From: Hornby, Mark [Mark.Hornby@lancashire.gov.uk]
Sent: 22 March 2012 14:30
To: Graeme Thorpe
Cc: Ian McCarten
Subject: Consultation on planning applications 3/2012/0051, 0052, 0053 at 41 Dilworth Lane, Longridge

Application 3/2012/0052 Triple garage / office

Application 3/2012/0053 Three dwellings and associated parking area

Tre felling Plan Phase 1/2&3

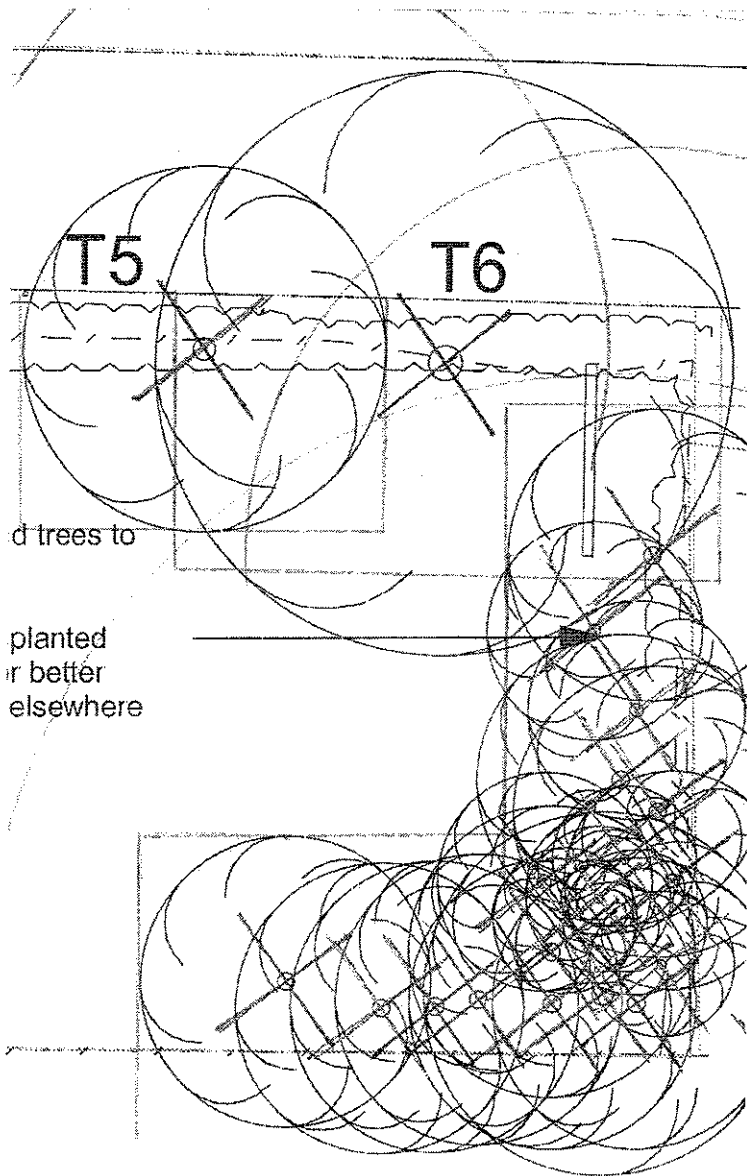
A visibility splay of 2.4m x 50m is achievable to the east with the removal of the first tree and to the west by lowering the frontage wall within the applicant's control to a maximum height of 1m, in conjunction with the relocation / realignment of the existing frontage fence and gateposts. This has been agreed in principle with the applicants agent as detailed on the attached plan and could be conditioned accordingly in any consent granted.

This is a resubmission of application 3/2011/0655. A satisfactory visibility splay of 2.4m x 50m at the proposed new access to the parking area can be achieved with the felling of a number of frontage trees and this has been agreed in principle with the applicants agent as detailed on the attached plan. The number of parking bays has been increased from 6 to 7 thus allowing two spaces per dwelling plus a visitor space. The parking area will need to be paved in suitable materials i.e. not loose gravel or similar and be available for use prior to occupation of the dwellings. The proposed dwellings have been moved back slightly from the edge of carriageway to allow a 1.5m footway and facilitate good visibility to the east. I would ask however that the railings to the front of the proposed dwellings be removed from the plans as they appear to encroach on the available footway width. Subject to these points being addressed satisfactorily I have no objection to the proposal.

It would be prudent to have revised site plan drawings submitted for applications 0052 and 0053 incorporating all the above points to clarify the access and parking arrangements for any consent granted
